From: Peter Wilmott
Sent: 23 October 2018 18:02
To: Raymond Proctor
Cc: Martyn.white@arun.gov.uk
Subject: Bridge Club, Sudley Road, Bognor Regis -
Attachments: 20181023185532935.pdf

Project No./Ref: 300582/SK/1
 Project: THE BOONOR CHOPS
 Section: FRONT WALL - REMEDIAL WORKS
 Prepared: RW Checked: Date: 07/2018 Time:

From: Peter Wilmott
Sent: 10 January 2019 17:41
To: Martyn White
Cc: [REDACTED]
Subject: RE: The Bognor Club Wall - Application for Listed Building Consent.
Attachments: Bridge Club, Sudley Road, Bognor Regis - ; 20190110180630844.pdf; 20190110181002887.pdf

Project No./Ref: 300582/SK/1
 Project: THE BOGNOR JOB
 Section: FRONT WALL - REMEDIAL WORKS
 Prepared: RW Checked: Date: 05/2018 Time:

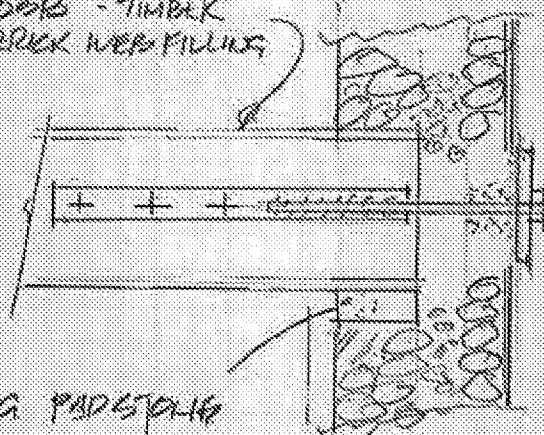
The opening up works on Saturday comprised an exposure of the north side of the north beam bearing. This enabled the full depth of beam bearing to be seen and also the inside surface of the outer "skin". As a result of my inspection I have established that the wall is entirely flint construction and is built with an inside "skin" 225mm thick, an outside "skin" of flint rendered to external face and a rubble core. The bowing movement of the external face of the wall is indeed skin separation with the outer "skin" moving away from the core having lost its initial

bond. The inner "skin" is restrained by the steel beams (not of the same age as the building) over the Billiards Room which bear on this part of the wall and is stable. The appearance of bearings is satisfactory and the beams are of robust section. All this is shown on the attached sketch 30058/sk/1 and photographs. The stability of the outer "skin" is not satisfactory and there is a likelihood that the outward movement will be progressive leading ultimately to a risk of collapse. The period of time for this to happen cannot be predicted with any certainty and as a result I am advising that the skin is anchored to the steel beams in the manner shown on my sketch. This will result in two pattress plates showing on the face of the wall a restraint detail commonly employed in such situations. By copy e-mail to Arun District Council I am asking if this proposal can be treated as an essential repair to be implemented as soon as possible. I am aware that ordinarily works to a Listed Building would be subject of Listed Building Consent but the process required to achieve this would take some time. The access tower erected by your builder has been left in place and given approval to progress the works in the near future this can be used for the installation process resulting also in cost savings for the club.

On completion of the two anchors the external skin will be stabilized. I would then advise that the CamTies or equal are installed on a grid to be agreed approximately 450mm centres vertically x 900mm centres horizontally. This installation would be to improve the overall anchorage of the front skin of the front wall and to achieve some core grouting. There would need to be some consultation with the tie manufacturer regarding installation in flint construction. If found impractical I would look at other options.
